CITY OF ALBUQUERQUE

April 25, 2013

Re: American Tire Warehouse Addition, Grading and Drainage Plan Engineer's Stamp Date 03-27-2013 (C-17/D015)

A1 SITE GRADING PLAN

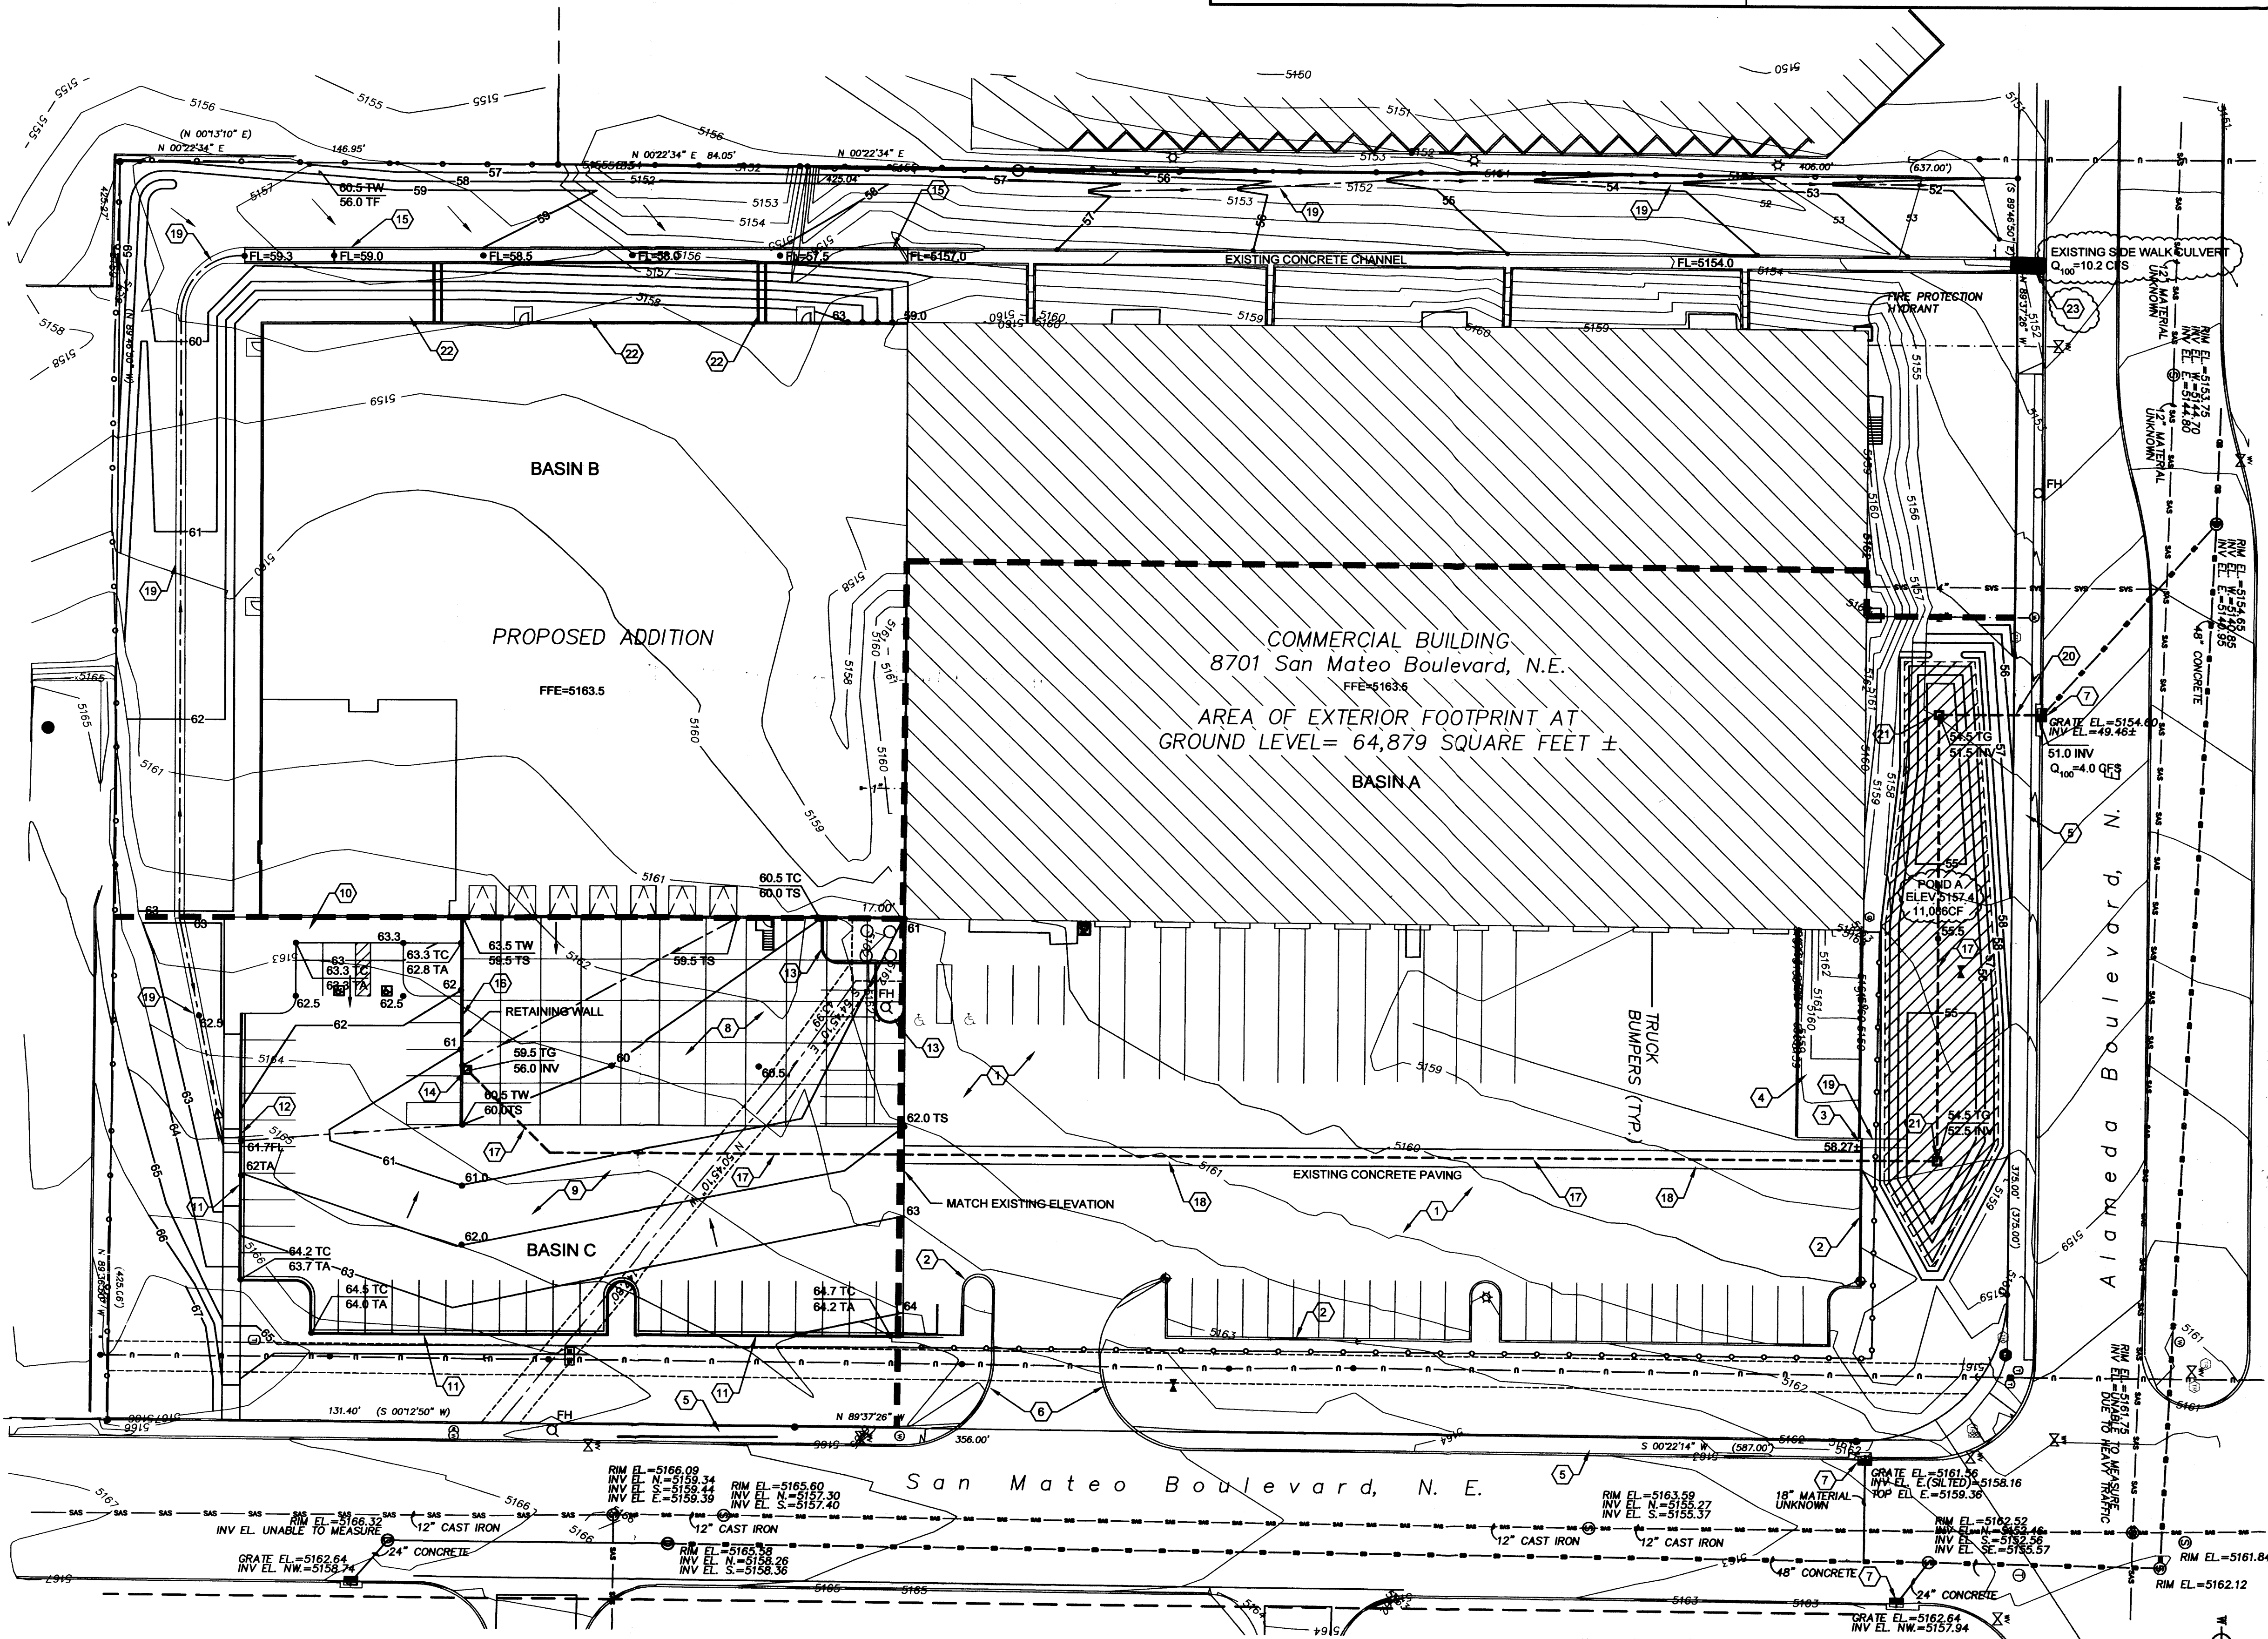
- Please provide routing calculations to show how the proposed pond will drain over time.
- It appears that the proposed discharge rate of 14.4 cfs will exceed the limit set forth by the SAD 201 drainage report of 14.2 cfs; please provide all supporting documentation reflecting this limitation.

- The pipe connection to the back of the existing inlet will need to be constructed under SO-19 guidelines and inspected. The SO-19 standard language should be placed on the grading plan.

- It appears that a portion of the flows on the southwestern edge of the property are being directed towards the adjacent lot. How will these flows be contained?

- The 100-year water surface elevation should be shown on the proposed pond along with the pond volume; please provide a legend on the plan for clarification of line types. If the pond will take longer than 6 hours to drain a 24-hour storm event will be required for pond sizing.
